Rezoning Transportation Analysis

Petition Number: Zoning Petition #2021-004

General Location Identifier: Tax ID 08117410

Date	Description
02-25-2021	First Review (WB)
03-25-2021	Second Review (WB)
05-25-2021	Third Review (WB)

**A100**

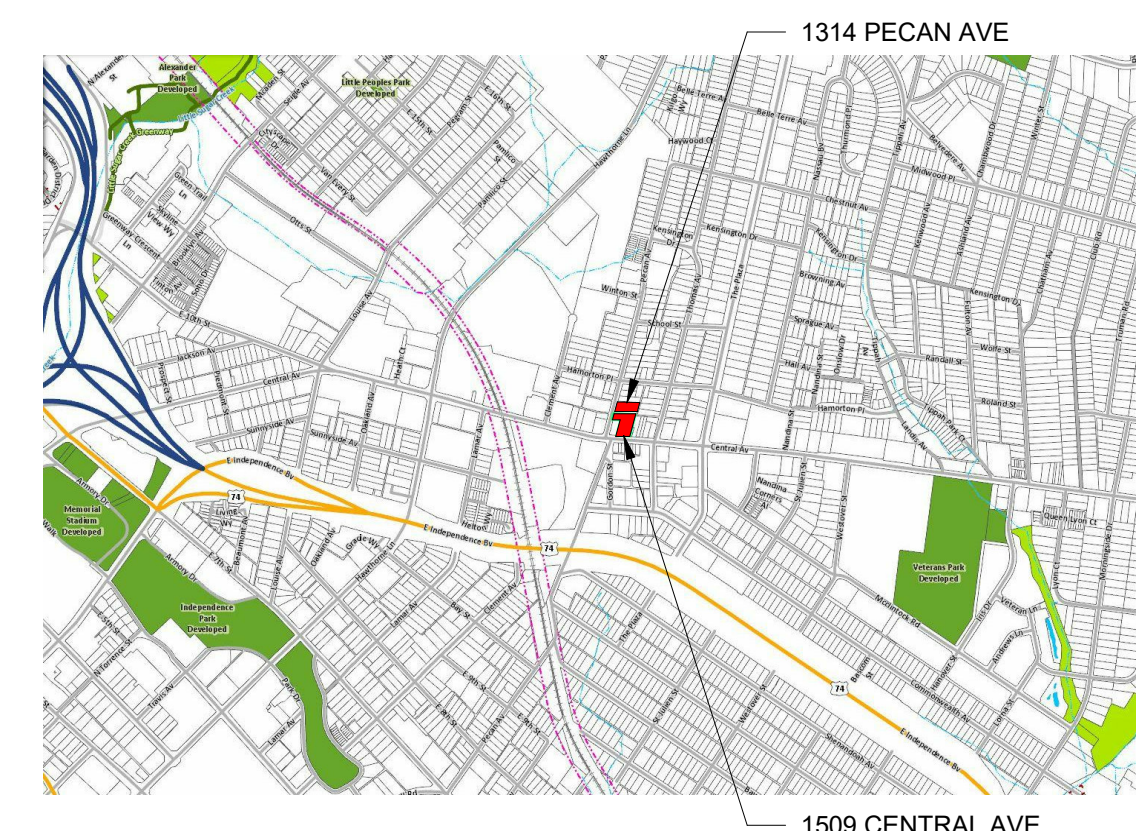
~~Revised based on site plan dated 03/15/2021.~~

A100

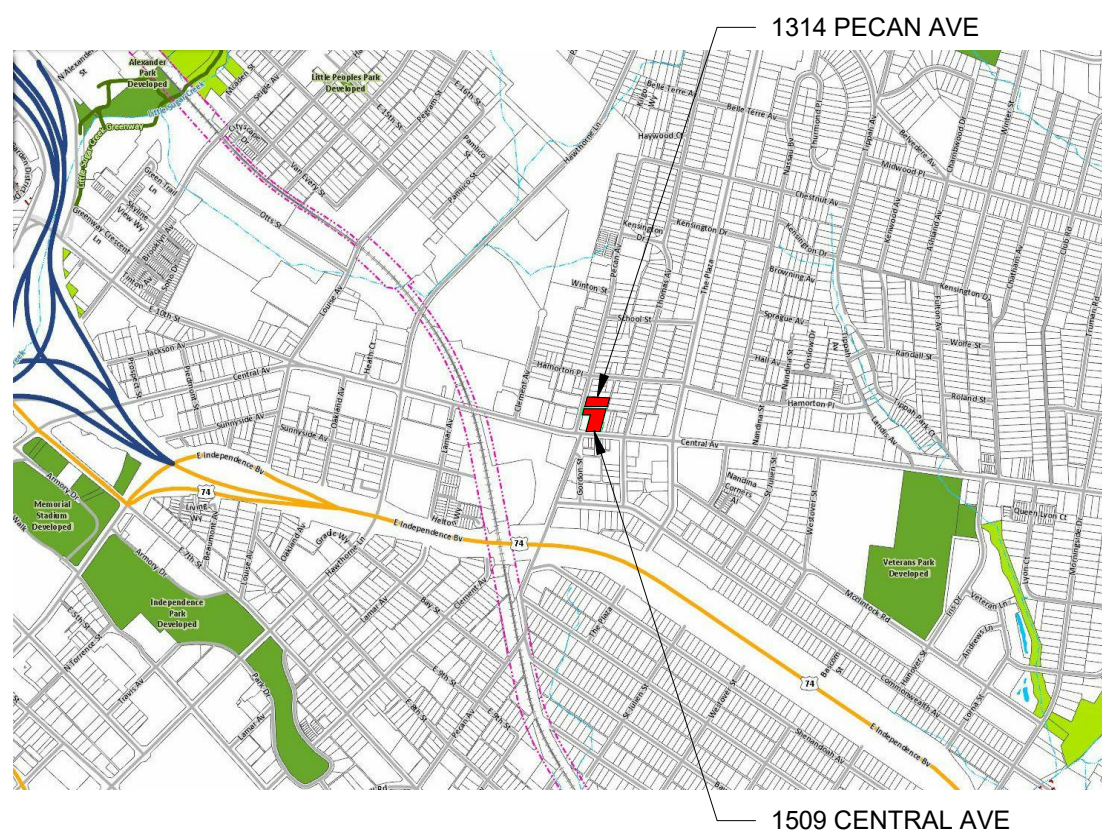
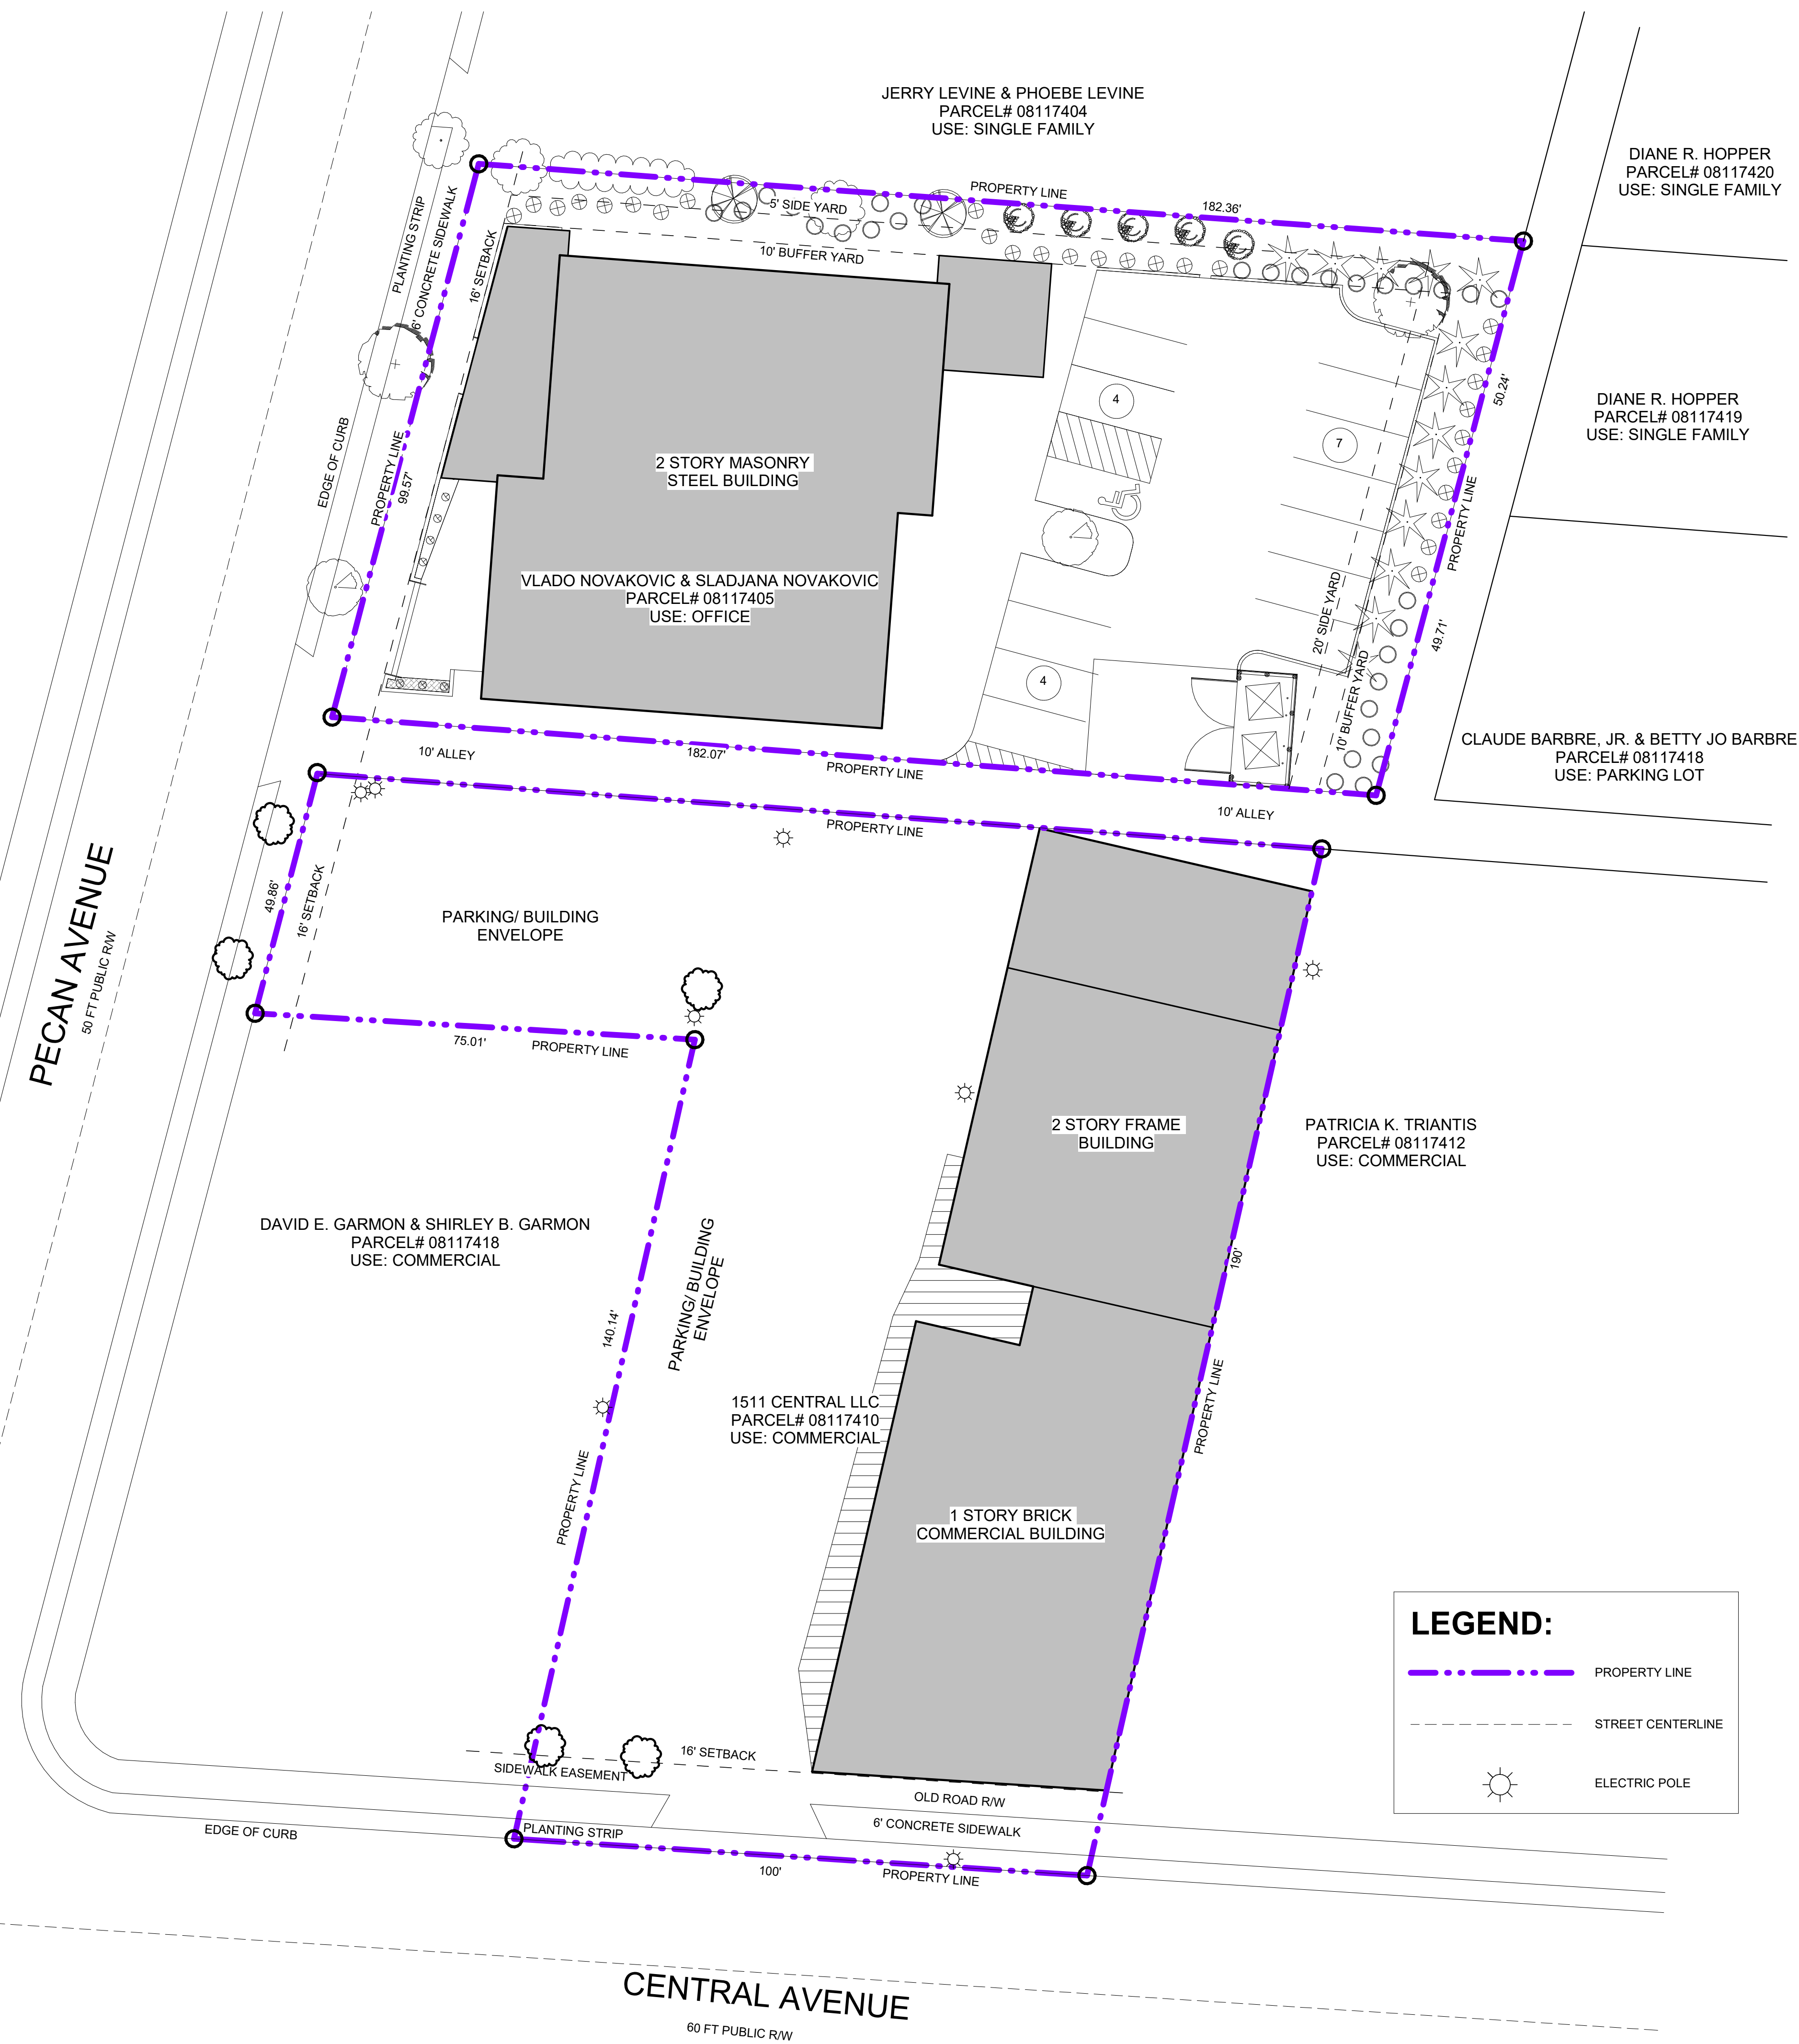
1. Curblines:

a. ~~Central Avenue:~~ The existing curb and gutter is at its future location. The curb does not need to be relocated with this project.

b. ~~Pecan Avenue:~~ The existing curb and gutter is at its future location. The curb does not need to be relocated with this project.

Label and dimension the existing curb and gutter from the centerline for each road on the site plan. ~~Resolved (3/15/2021)~~

4. ~~Revise site plan and conditional note(s) to commit to dedicating 40' right-of-way from the Central Avenue road centerline. The site plan shall label and dimension the right-of-way from the road centerline.~~

5. ~~Revise site plan and conditional note(s) to commit to providing a 15' sidewalk at the back of curb on Central Avenue, per Chapter 19 and the Plaza-Central Pedscape Plan. The site plan shall label and dimension the sidewalk from the back of curb and gutter. Resolved (3/15/2021)~~

6. ~~Revise site plan and conditional note(s) to commit to construct an 8-foot planting strip, and an 8-foot sidewalk on Pecan Street per Chapter 19, CLDSM U-05A and the Plaza-Central Pedscape Plan. The site plan shall label and dimension both items from the back of curb and gutter. Resolved (3/15/2021)~~

7. ~~Revise site plan Conditional Note II.d. to the following: "To not require the installation of streetscape improvements along Central Avenue when change of uses or building expansions occur if Chapter 19 is not triggered. Should a future building expansion trigger Chapter 19 requirements, pedestrian and drainage facilities will be required." Resolved (3/15/2021)~~

8. ~~Add a site plan note specifying dedication and fee simple conveyance of all rights-of-way to the City before the site's first building certificate of occupancy is issued is needed. CDOT requests rights-of-way set at 2' behind back of sidewalk where feasible. Resolved (3/15/2021)~~

9. ~~Add a site plan note specifying that all transportation improvements will be approved and constructed before the site's first building certificate of occupancy is issued is needed. The petitioner may phase transportation improvements if said improvements and phasing are explicitly described in site plan notes. Resolved (3/15/2021)~~
